5816 1-25 Mulready Ground Fl
20 Apr 2021

Millbank Estate
5816

Gunite
United Living

EXISTING ELEVATION A (NORTH)
Scale 1:100

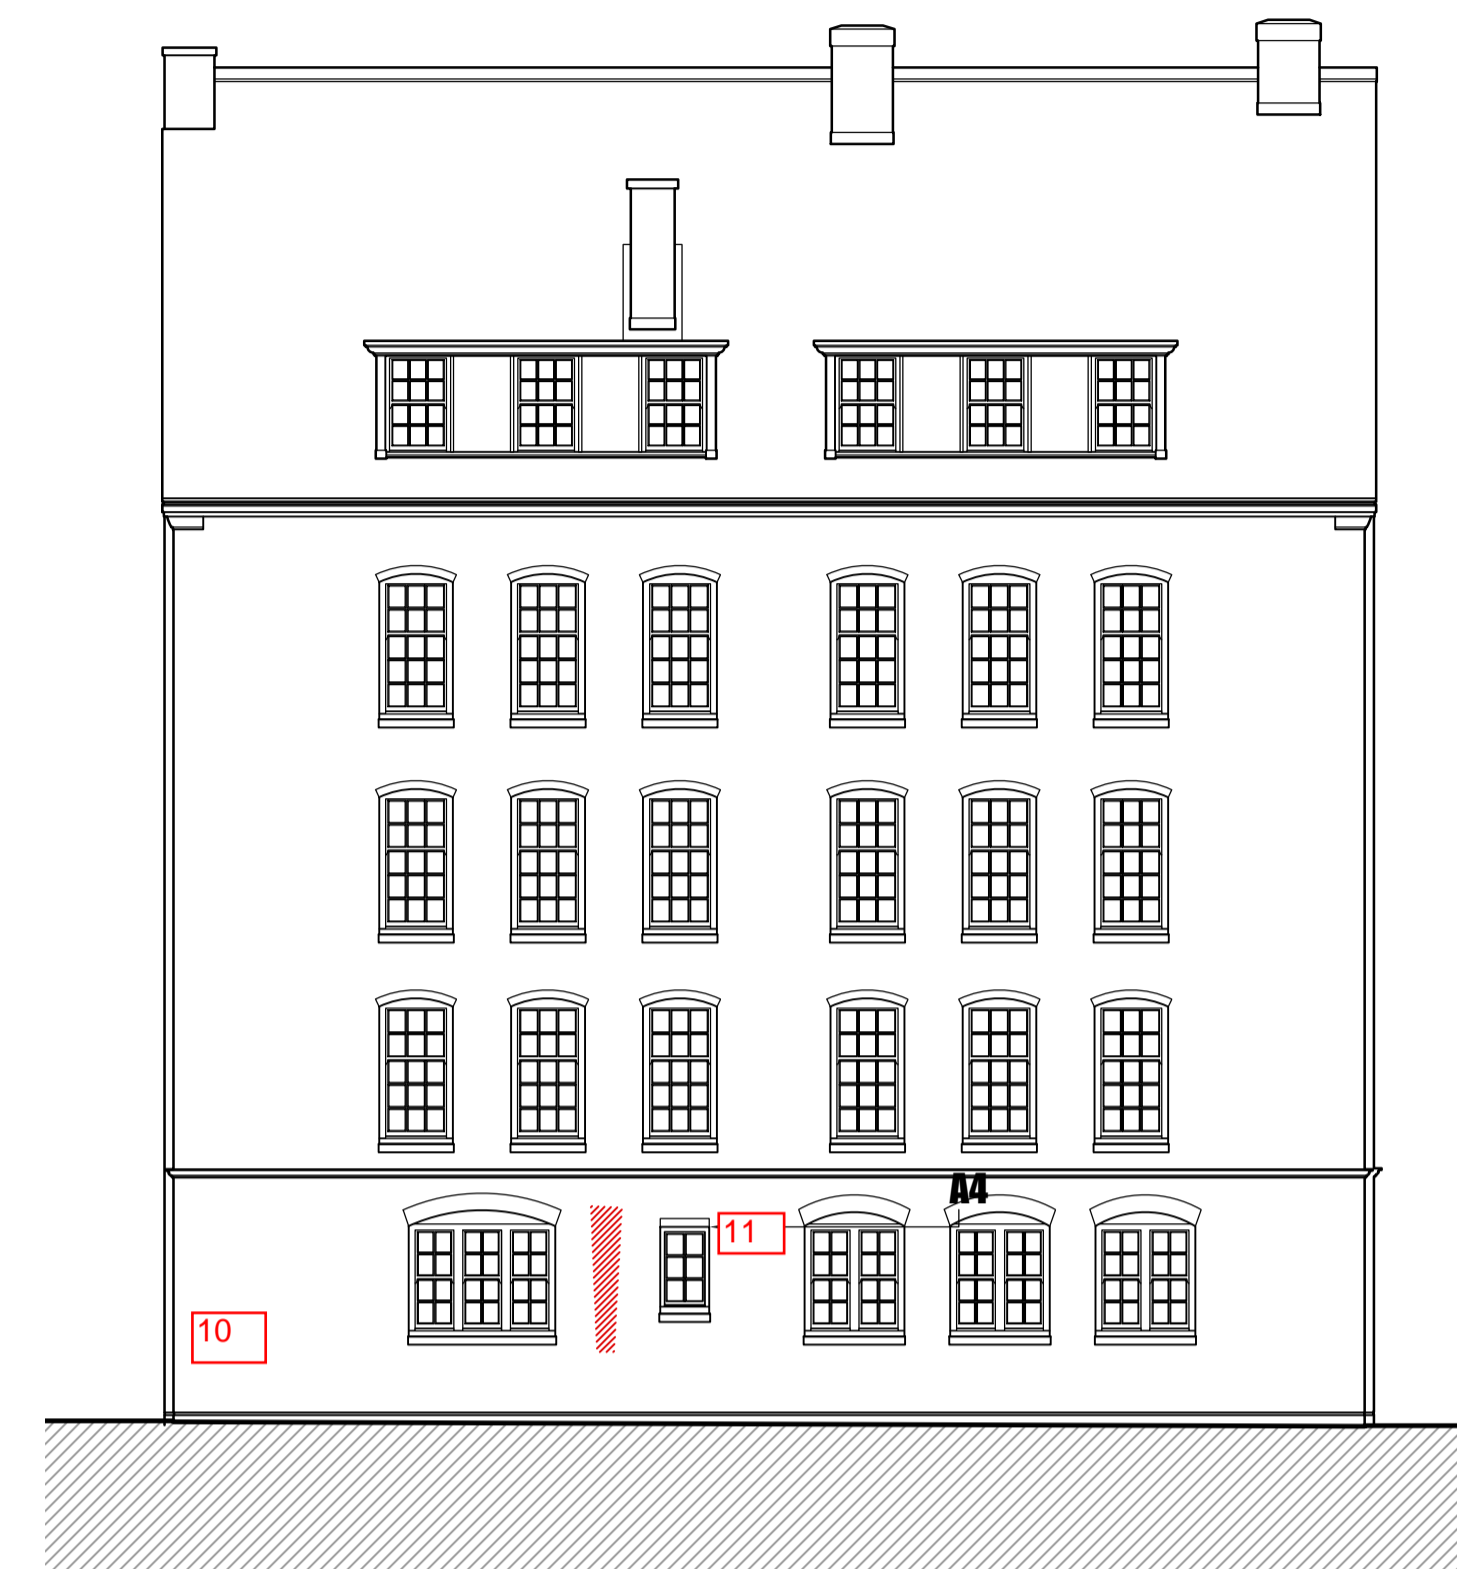
ITEM
12
FLOOR
Ground
ROOM
Elev A
SHEET

ISSUE
1 brick to replace

ITEM
13
FLOOR
Ground
ROOM
Elev A
SHEET

ISSUE
7 helibars, 8 bricks to replace

EXISTING ELEVATION C (SOUTH)
Scale 1:100

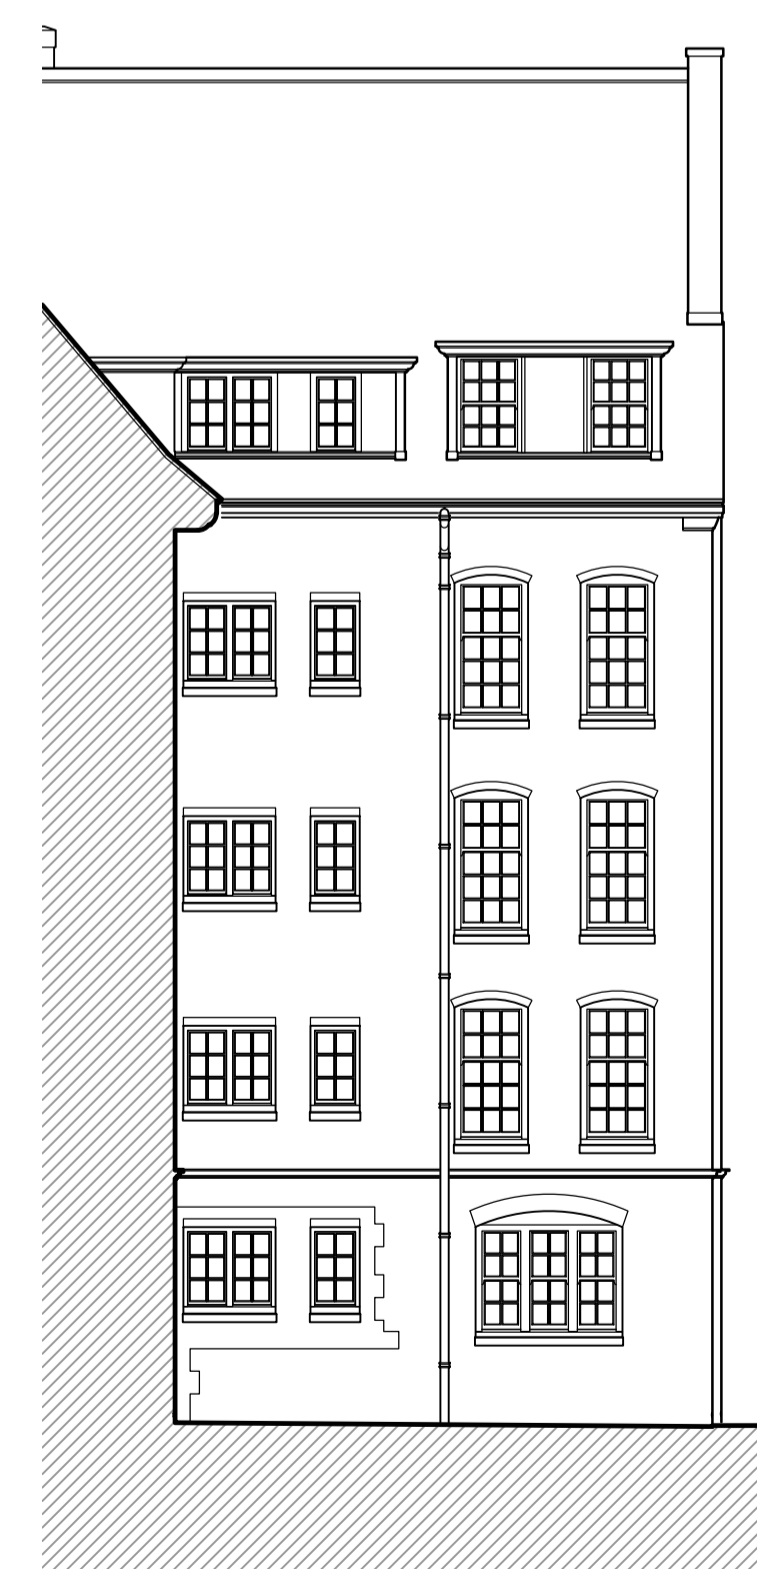
ITEM
1
FLOOR
Ground
ROOM
Elev C
SHEET

ISSUE
1 brick to replace

ITEM
2
FLOOR
Ground
ROOM
Elev C
SHEET

ISSUE
12 bricks to replace

ITEM
3
FLOOR
Ground
ROOM
Elev C
SHEET

ISSUE
8 bricks to replace

ITEM
4
FLOOR
Ground
ROOM
Elev C
SHEET

ISSUE
1 brick to replace

ITEM
5
FLOOR
Ground
ROOM
Elev C
SHEET

ISSUE
1 brick to replace

ITEM
6
FLOOR
Ground
ROOM
Elev C
SHEET

ISSUE
Render repair

COMMENTS
120x100

ITEM
7
FLOOR
Ground
ROOM
Elev C
SHEET

ISSUE
Render repair

COMMENTS
200x130

ITEM
8
FLOOR
Ground
ROOM
Elev C
SHEET

ISSUE
1 brick to replace

ITEM
9
FLOOR
Ground
ROOM
Elev C
SHEET

ISSUE
1 brick to replace

ITEM
18
FLOOR
Ground
ROOM
Elev C
SHEET

ISSUE
17 bricks

COMMENTS
Existing brick repairs

ITEM
19
FLOOR
Ground
ROOM
Elev C
SHEET

ISSUE
6 bricks

COMMENTS
Existing brick repairs

ITEM
20
FLOOR
Ground
ROOM
Elev C
SHEET

ISSUE
4 bricks

COMMENTS
Existing brick repairs

ITEM
21
FLOOR
Ground
ROOM
Elev C
SHEET

ISSUE
18 bricks

COMMENTS
Existing brick repairs

EXISTING ELEVATION E (WEST)
Scale 1:100

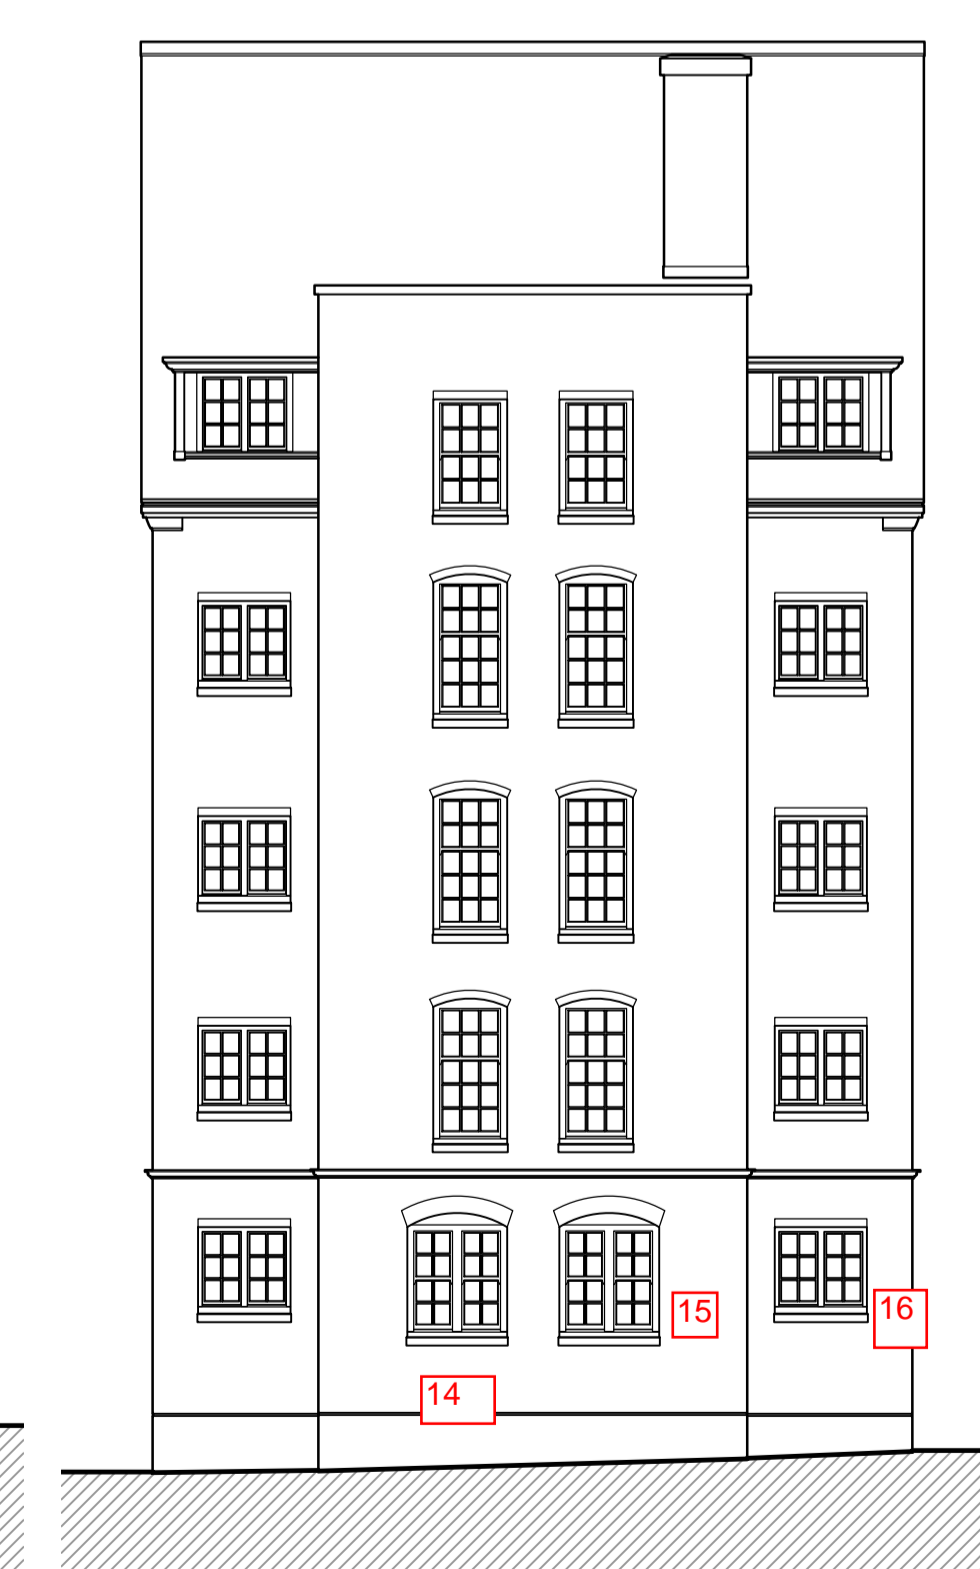
ITEM
14
FLOOR
Ground
ROOM
Elev E
SHEET

ISSUE
3 helibars, 3 bricks to replace

ITEM
15
FLOOR
Ground
ROOM
Elev E
SHEET

ISSUE
1 brick to replace

ITEM
16
FLOOR
Ground
ROOM
Elev E
SHEET

ISSUE
1 brick to replace

ITEM
17
FLOOR
Ground
ROOM
Elev E
SHEET

ISSUE
1.8 lm DPC failed pointing
